## **BIOSCAN UK LIMITED FOR CLAYDONS SOLAR ACTION GROUP (CSAG)**

**Written summary of oral submissions made by Dominic Woodfield for CSAG at ISH2 including post hearing submissions.**

TITLE:
FIGURE 3.8.2
INDICATIVE LOCATION OF PRIMARY AND
SECONDARY CONSTRUCTION COMPOUNDS

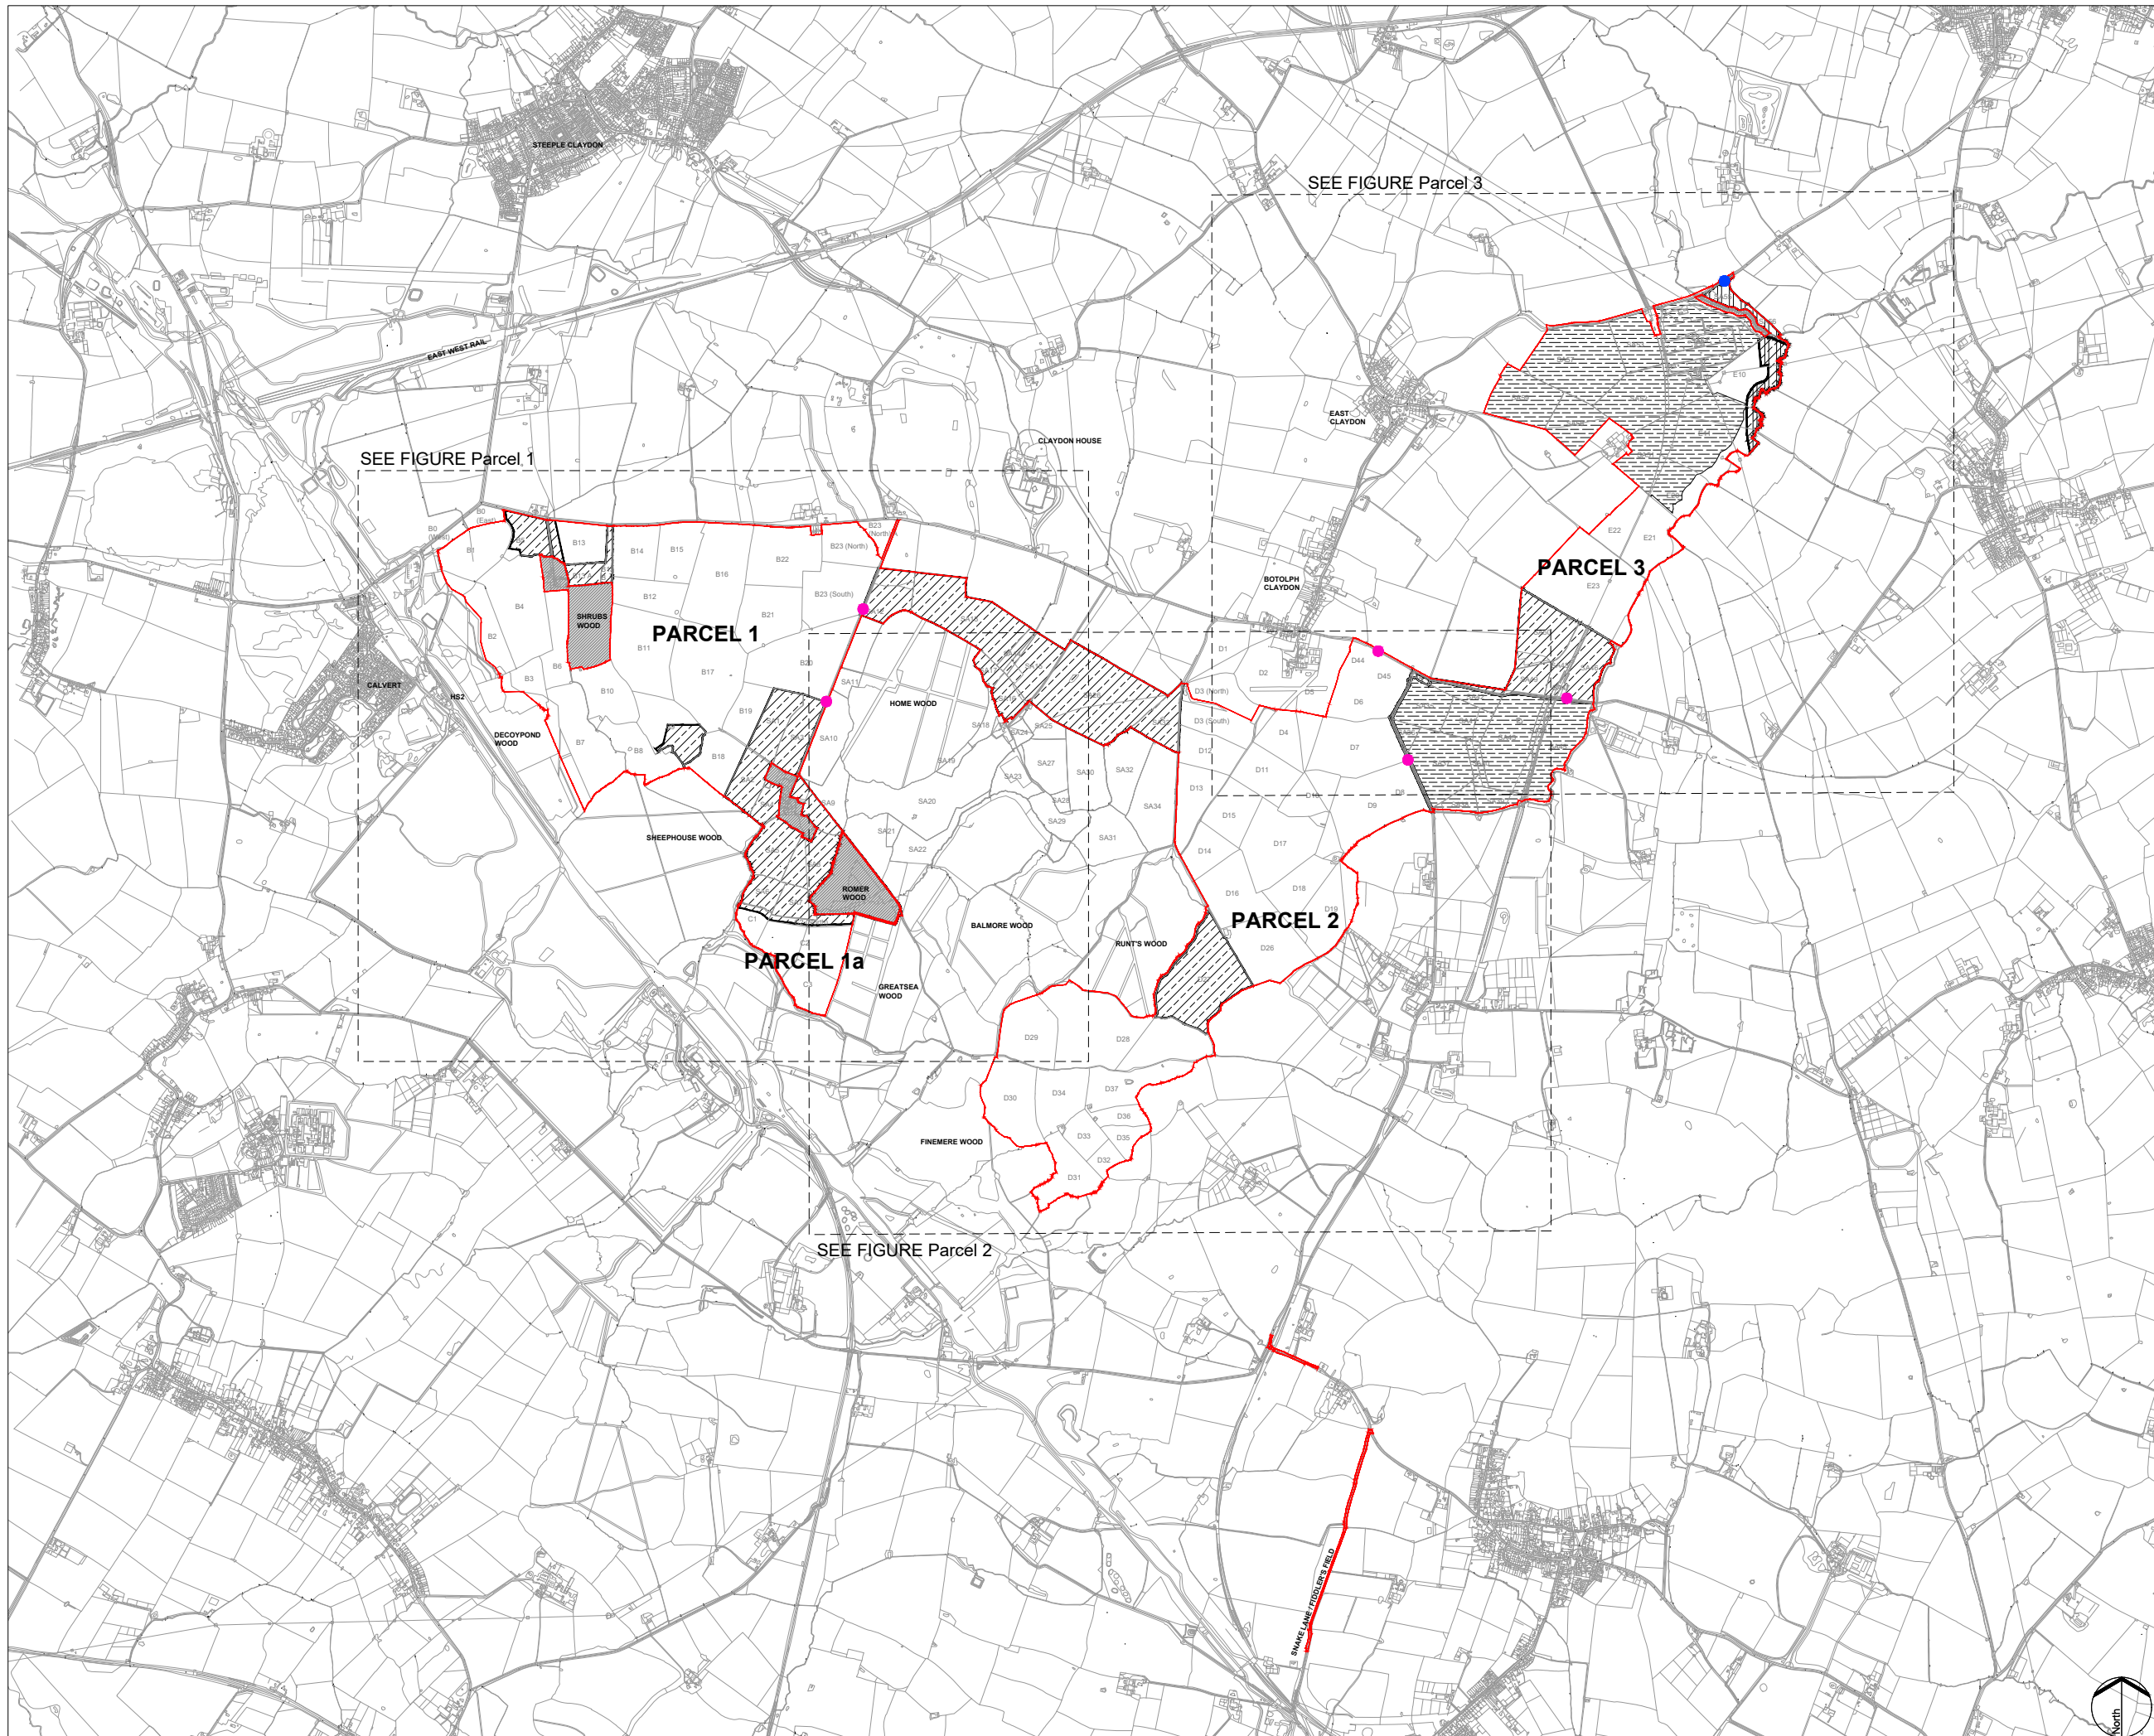
- 4.12 Mr Woodfield stated that *“The three fields that are of particular concern to Natural England and of concern to Bucks and of course my client; B6, B7 and B8 - no one has mentioned today that they are scheduled to be a construction compound for something like 2.5 years (e.g. see [APP-009](#) pdf page 4). That doesn't sit very well with this idea of everything being precautionary. Why would you put a construction compound on fields that are of acute concern to Natural England, and are the ones that they want to see taken out of the scheme in order to try and reduce the risks to the Bechstein's bats population?”*<sup>5</sup>.
